Subject: - Interconnection Application Request Received - Paul Meador

Duke Energy has received your request to interconnect a 9.45 Kilowatt Solar Photovoltaic System with Duke Energy Progress' system.

LINE DIAGRAM

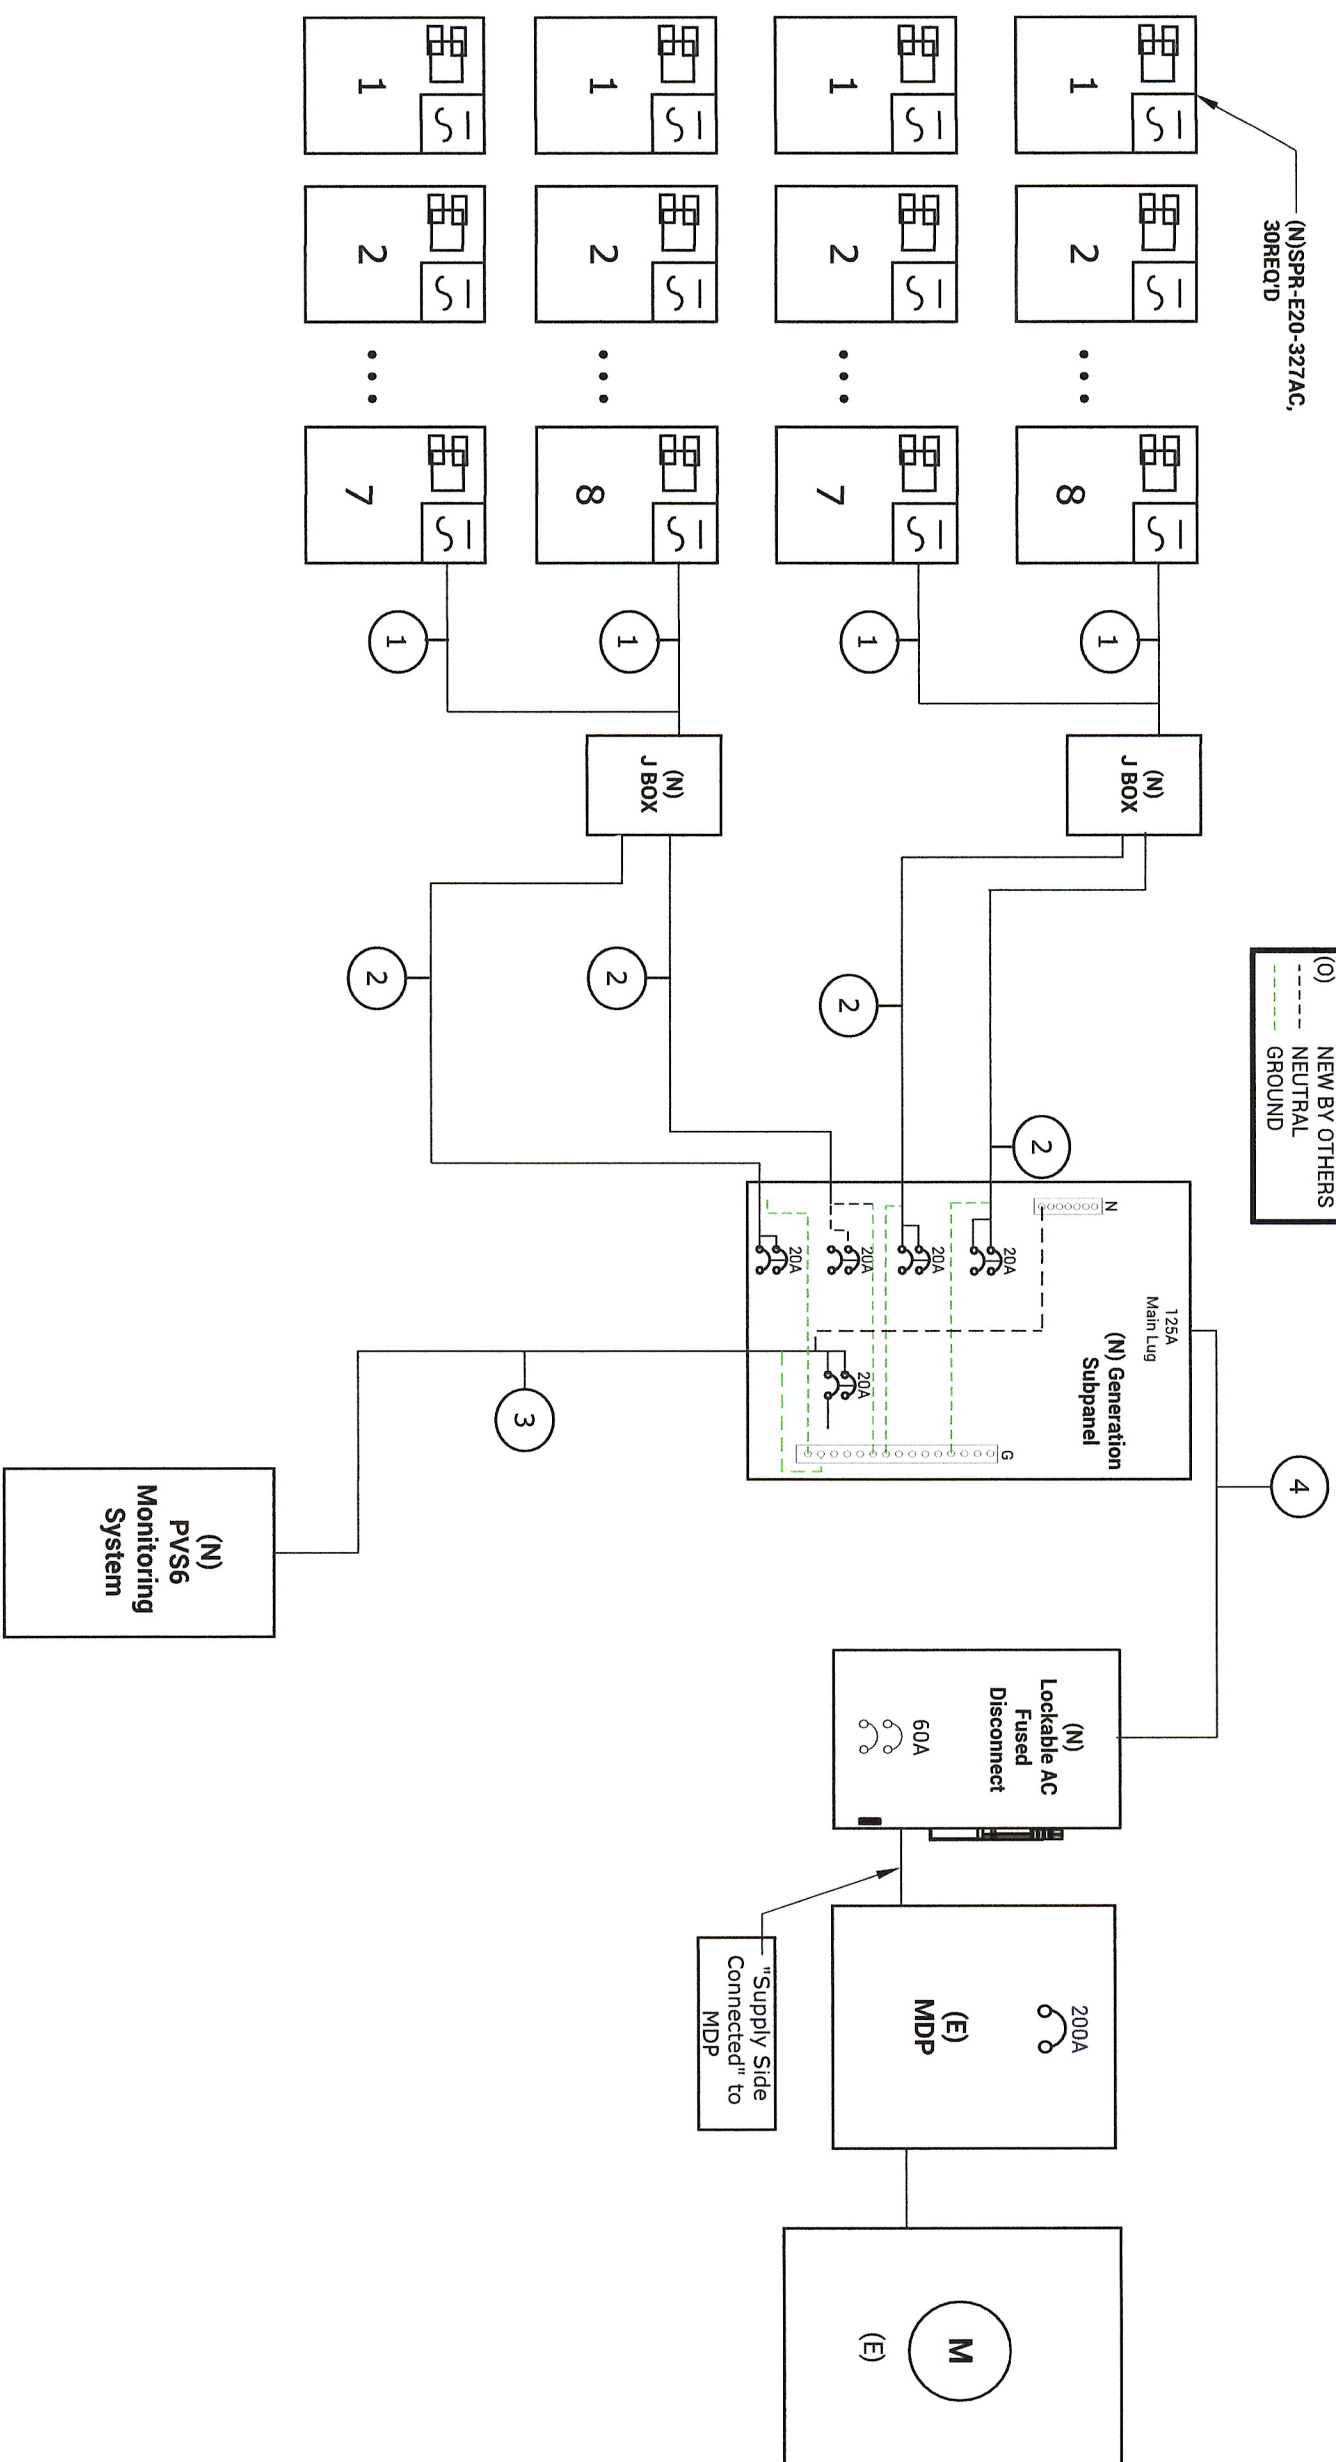
3. Electrical One Line Drawing: Yes Please add wattage to the one line drawing. Inverter 315 watts / Panels 327 watts
